An
Bord
Pleanála

Inspector's Report ABP 317227-23

10-Year Planning Permission sought for the development of a wind farm together with the development of an underground grid connection cable to the national grid. The development will consist of 8 wind turbines, a permanent meteorological mast, an on-site 38kV electrical substation, and all associated site works. An Environmental Impact Assessment Report (EIAR) and Natura Impact Statement (NIS) have been submitted with the application.

Fahy Beg, Fahy More N, Ballymoloney, Ballyknavin, Ballyquin More, Woodpark, Leitrim, Fahy More S, Ballybrack, Aharinaghmore, Tooreen, Aharinaghbeg, Knockdonagh, Roo E, Blackwater, Rosmadda West, Parkroe, Lacklyle, Castlebank and Ardataggle, Co. Clare.

TITLE:	Wind Farm Site Layout	
PROJECT:	Fahy Beg Wind Farm, Co. Clare	
FIGURE NO:	3.2	
CLIENT:	RWE Renewables Ireland Ltd.	
SCALE:	1:15000	REVISION: 0
DATE:	22/11/2022	PAGE SIZE: A3

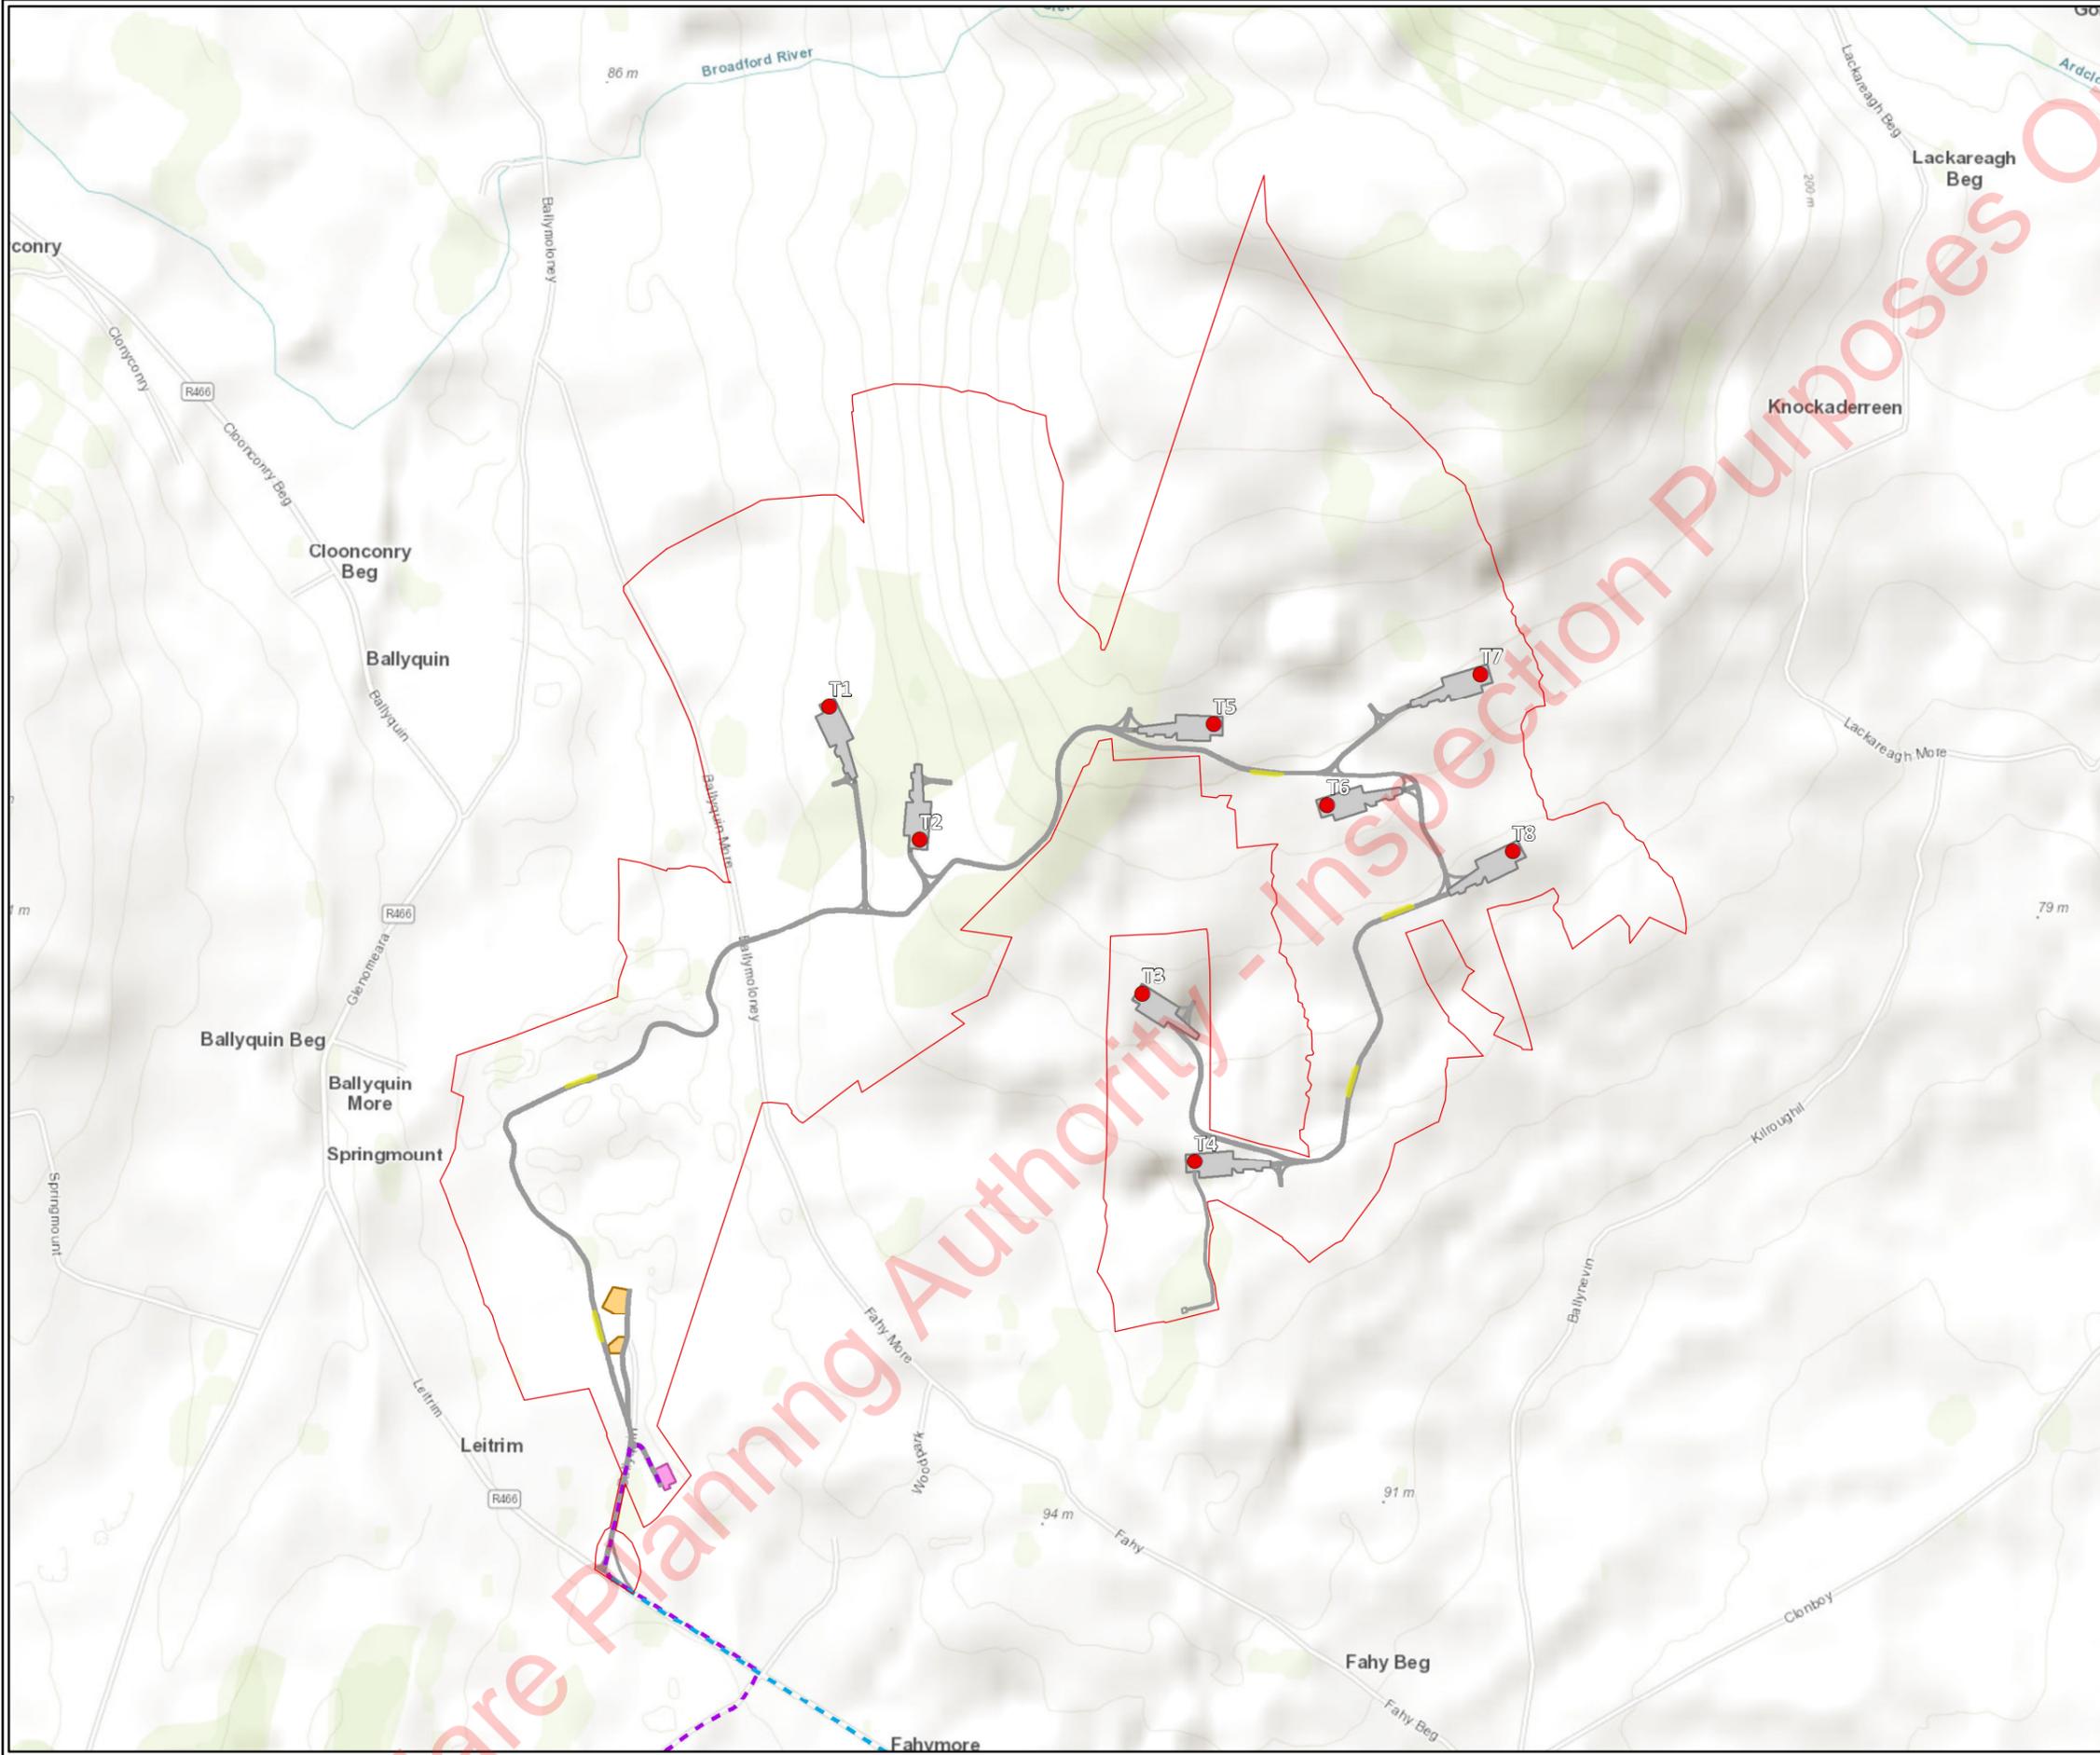
- It's noted that the turbines are labelled differently in the EIAR compared to the main planning drawings. The EIAR numbering for turbines differs from the drawings provided in the application dated 02/11/2022. For example, T3 in the EIAR corresponds to T8 in the drawings, and so on.
